BN/51/20/PL

I write to you to list our objections in respect of the above planning application.

Drawing No **LLD1880-ARB-DWG-002** Revision **00**

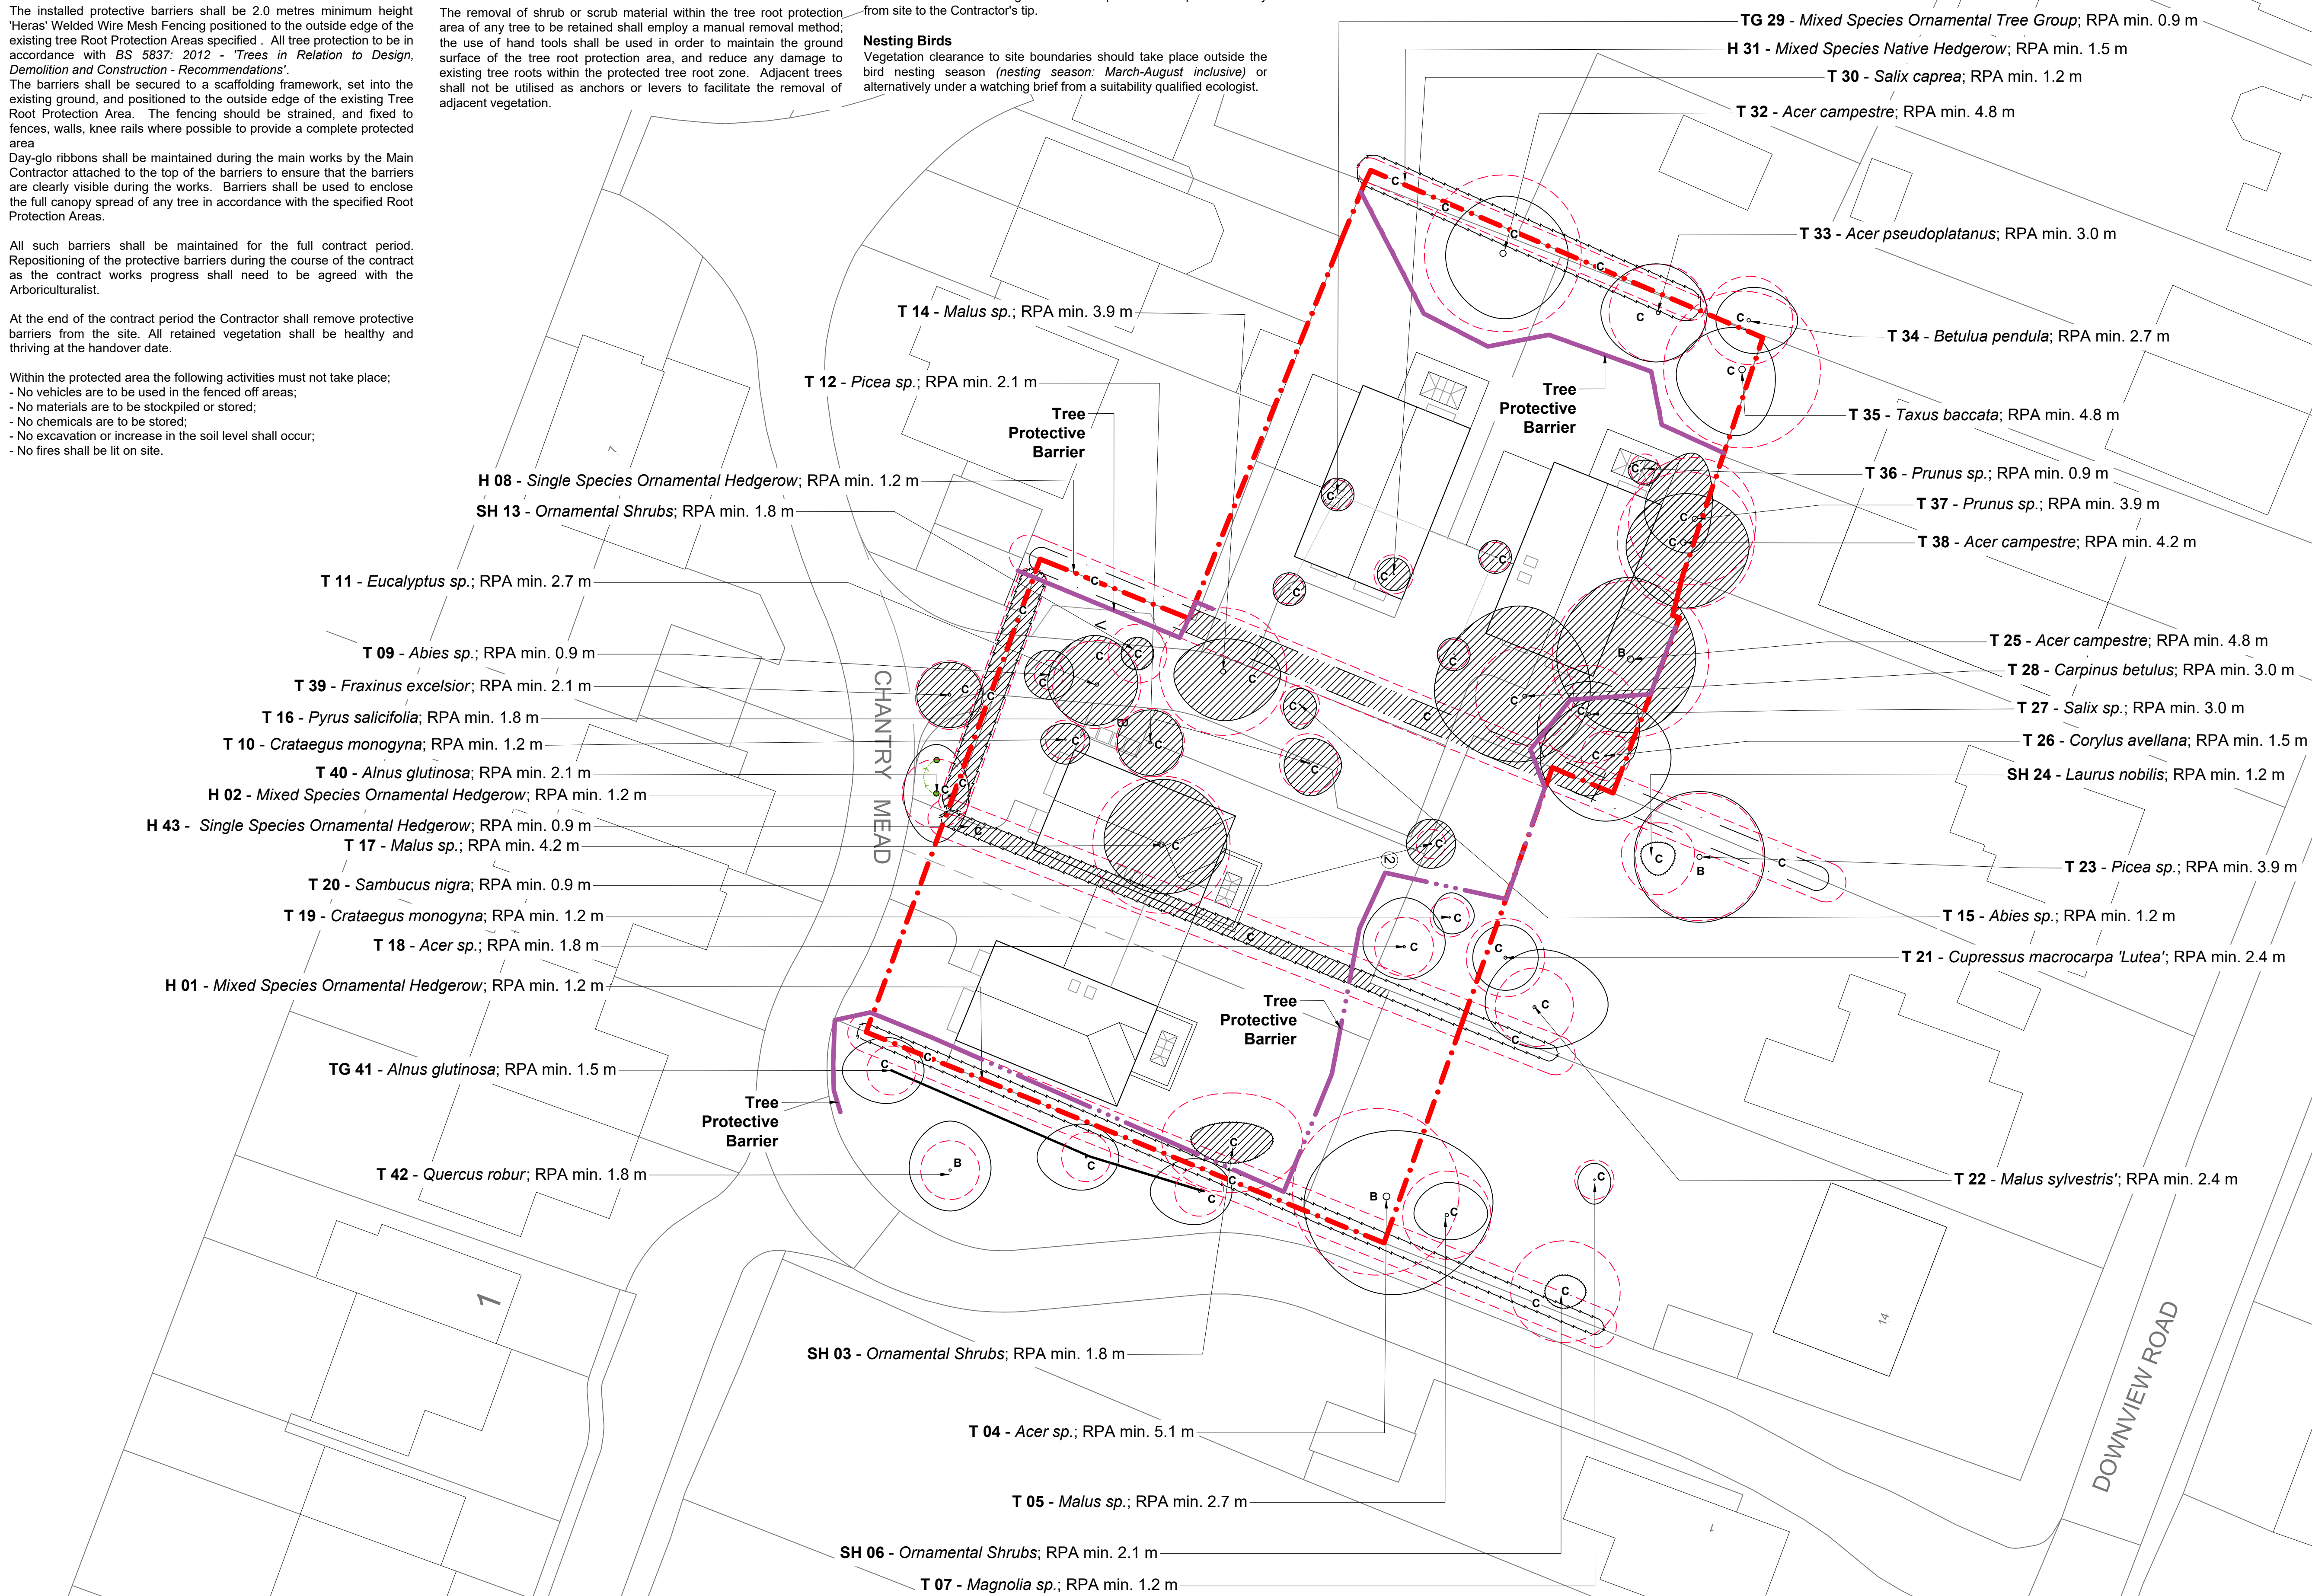
There are a considerable number of mature trees within the area covered by this planning proposal. One may reasonably assume that the great majority were planted for a reason by homeowners, rather

than random growth being allowed over the years. Some of these trees, as we can see from our property, are at least 30 feet high. It would be vandalism to allow them to be destroyed, as has one already. This is an area of Special Character and the loss of this garden area/wooded space will severely impact on flora/fauna/local environment.

Appendix A – Soakaway Test Location Plan

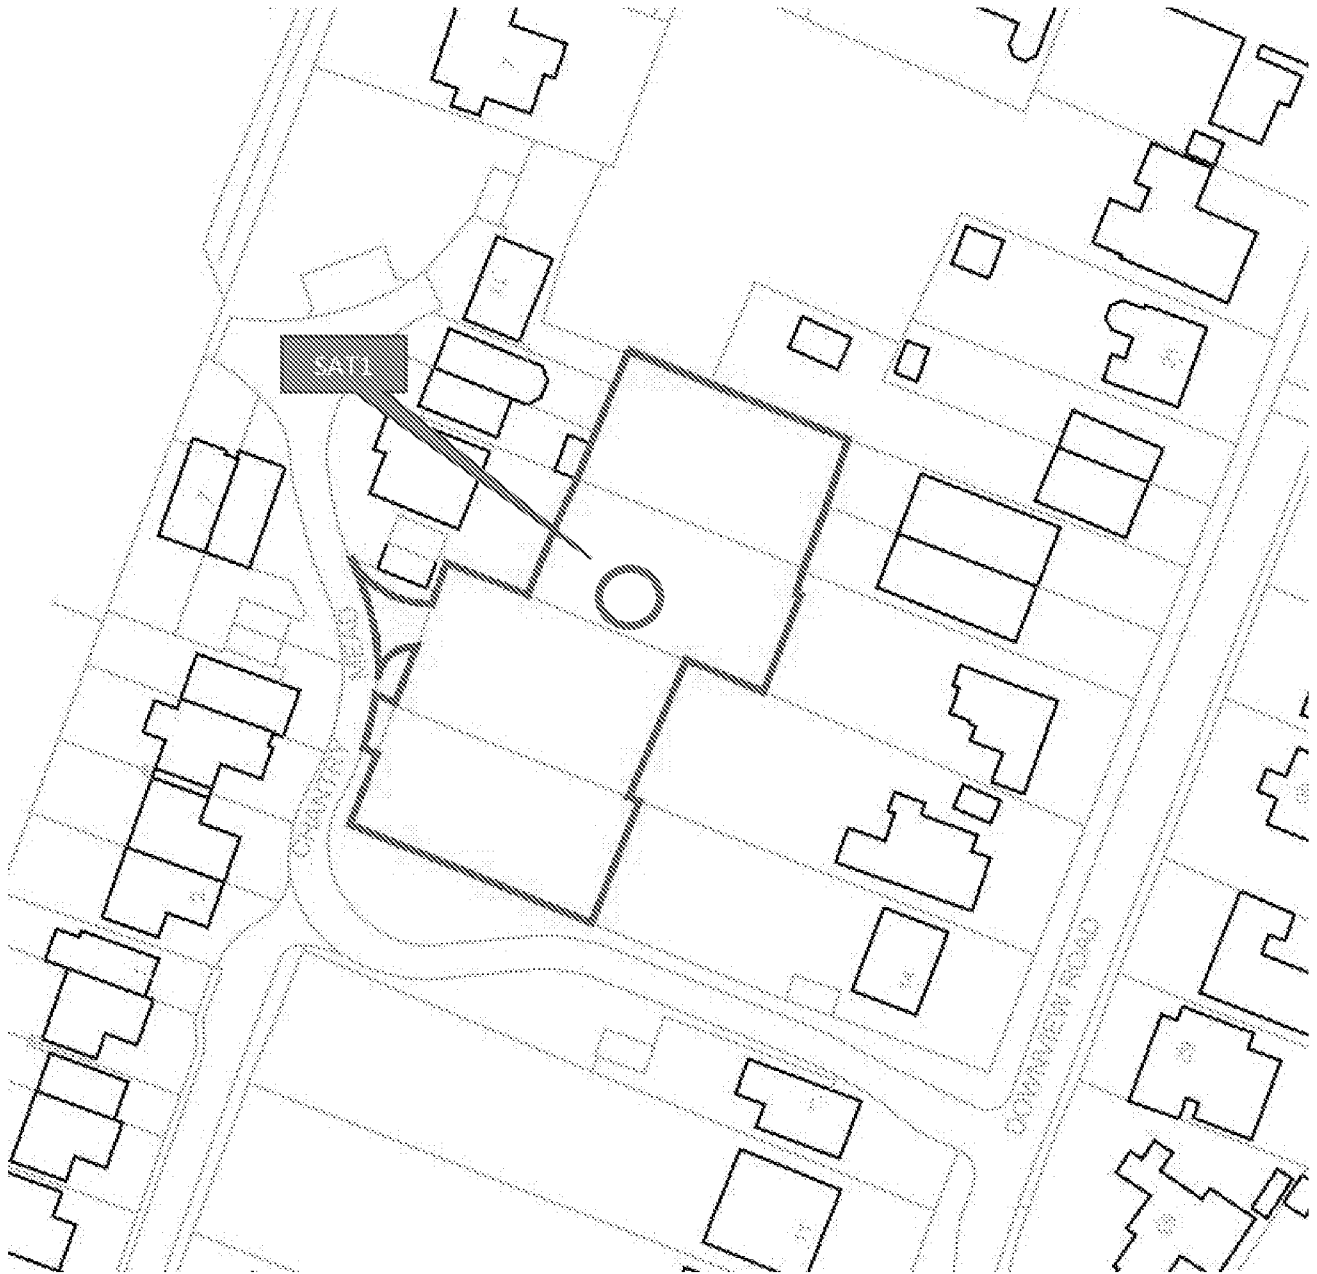
The original proposal for Chantry Mead included soakaways but this was rejected by the Environment Agency on the grounds that the locale could not provide the required 1 metre of unsaturated ground beneath infiltration units during wet winters. Since that time, some 10 years ago, best advice is that winters will become wetter. Why can this proposal be allowed therefore with small independent soakaways?
